Application for Removal or Variation of a Condition following Grant of Planning Permission or Listed Building Consent

Replacement shopfront including removal of canopy and installation of double doorsets

23/04701/FULL

Adjustment to the design of the Entrance Doors on the corner of Old Bond Street and Stafford Street: Approved solid timber doors to be replaced with glazed doors to match Approved shopfront in all respects.

1354.P4.350

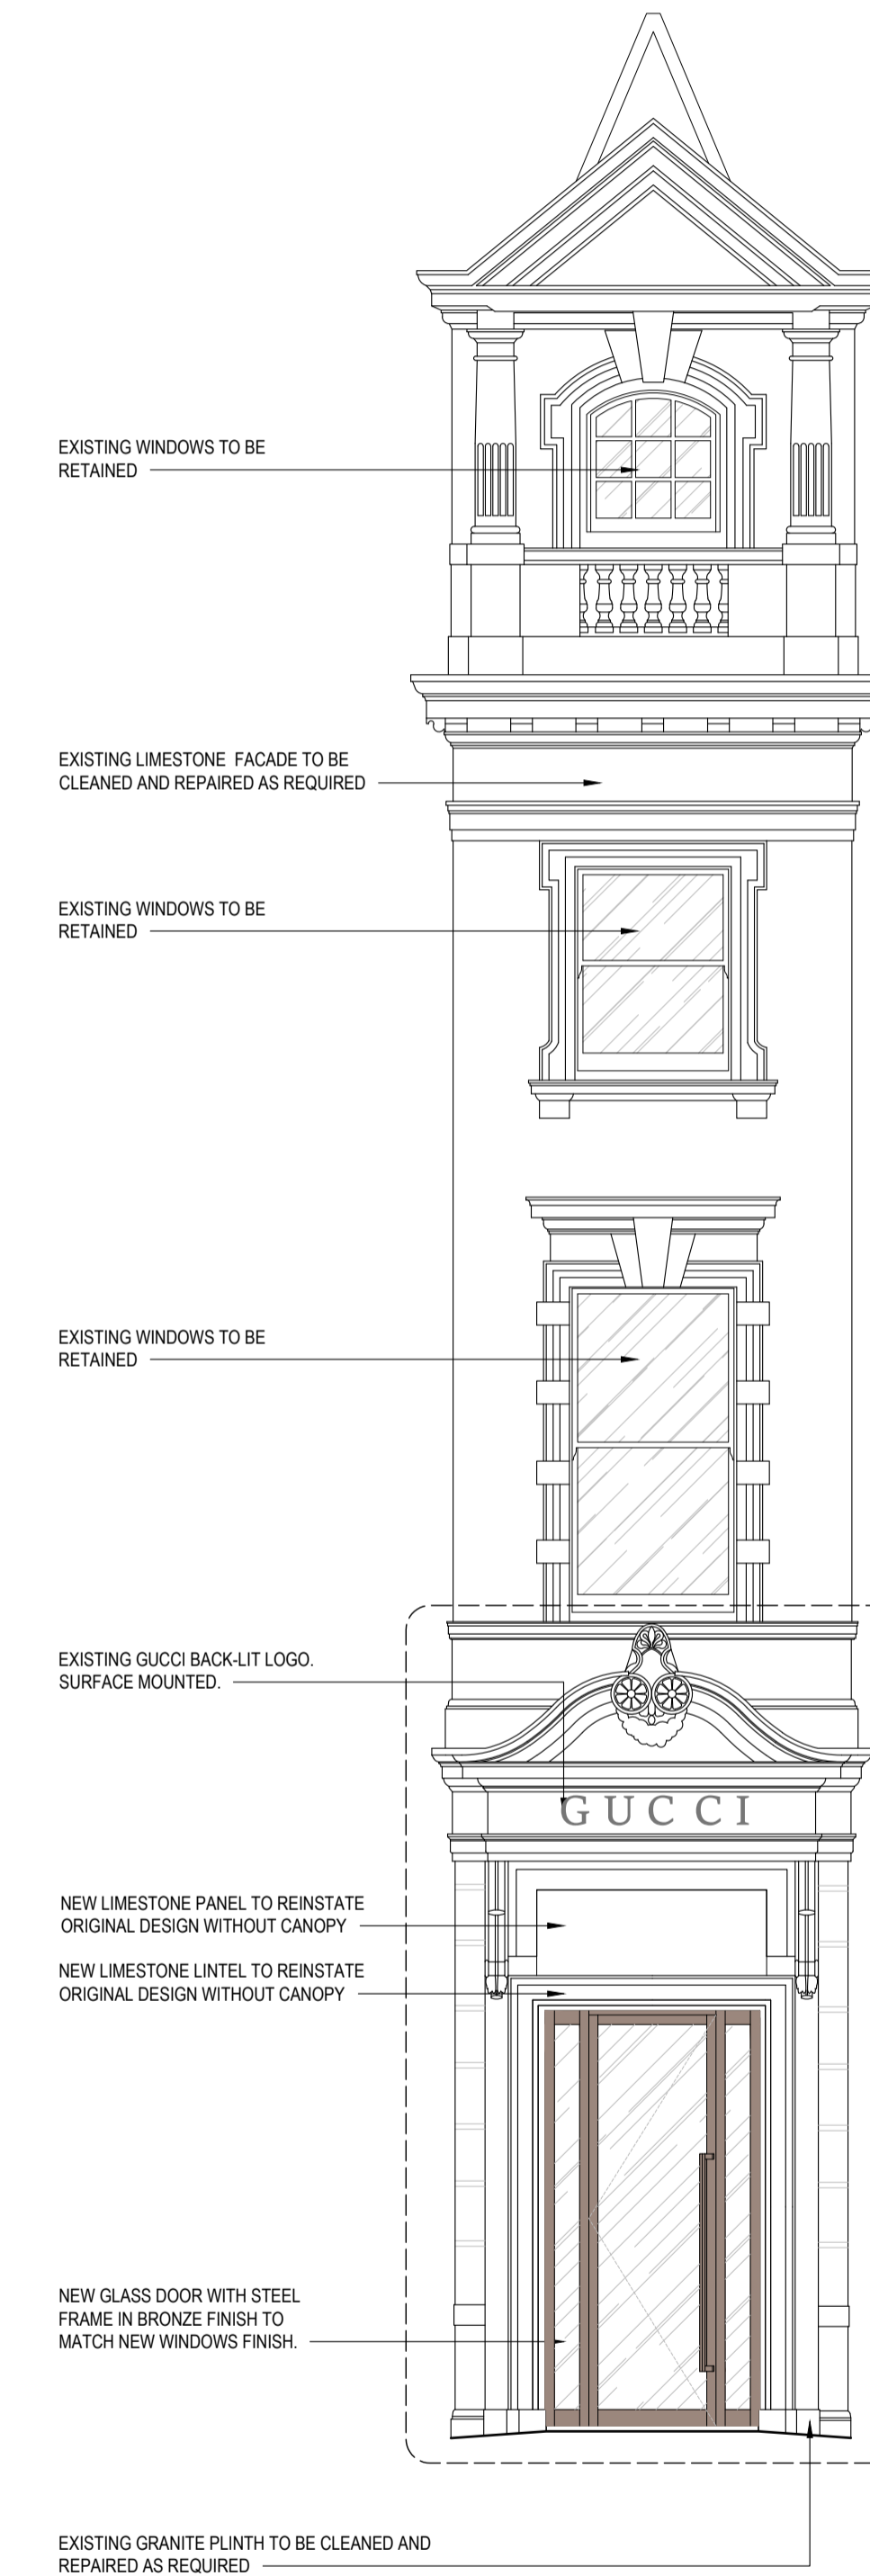
1/ Substitute Approved Proposed Ground Floor 1354.P2.100 for 1354.P4.300
2/ Substitute Approved Proposed Old Bond Street Elevation 1354.P3.100 for 1354.P4.350

UPDATE 2: The proposed Entrance Doors follow the design of the Approved shopfront in all respects.
